Application Ref: H16-0552-26

Proposal: **Erection of a 3-storey care home development with associated car parking, amenity space and ancillary structures**

Location: **Land off Shakespeare Way, Holland Park, Spalding**

Notice is hereby given that Lincolnshire County Council's formal recommendation is as follows:

Holland Park, Spalding  
Drainage layout

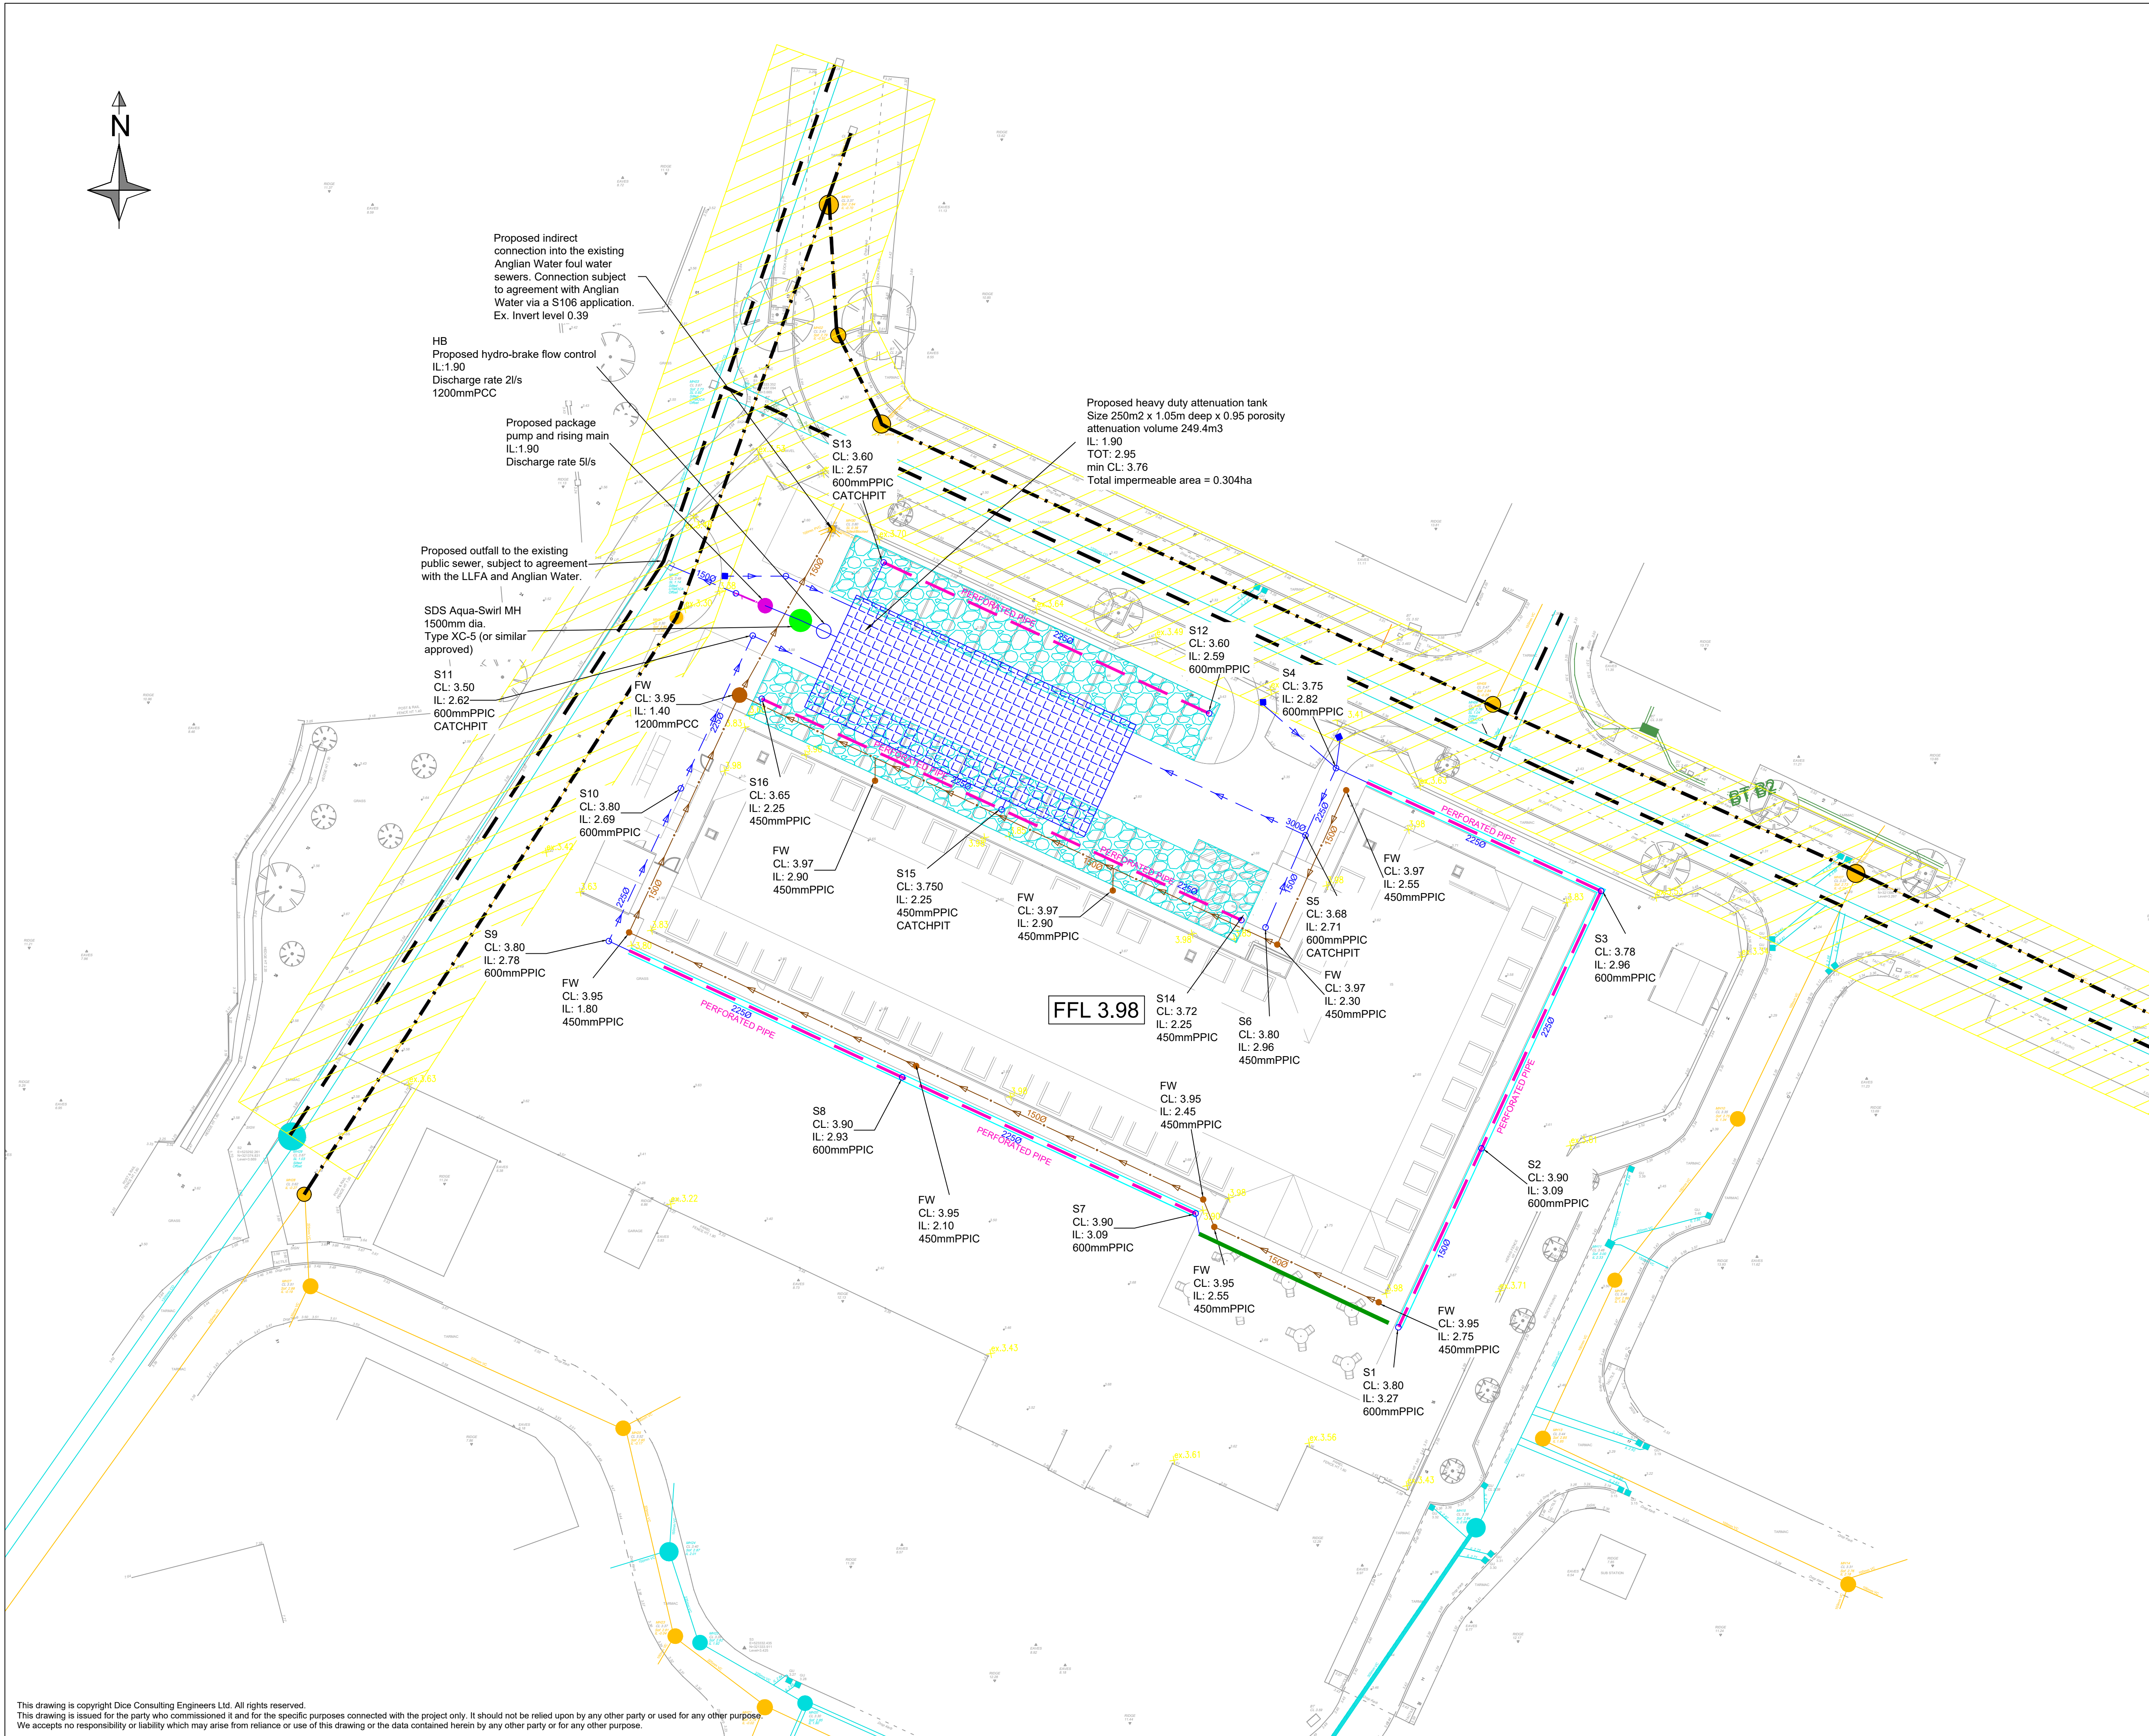
- Verification of the receiving surface-water sewer level and confirmation that the proposed gravity outfall is technically achievable. The submitted strategy currently indicates that a pumped solution may be required if the receiving sewer level is higher than anticipated.
- The calculated greenfield runoff rates, including QBAR, together with justification for the

proposed restricted discharge rate of 2l/s

- Clarification of the groundwater conditions, including the design groundwater level adopted, and confirmation that groundwater would not compromise the capacity, structural integrity, or operation of the proposed attenuation tank and other SuDS features.
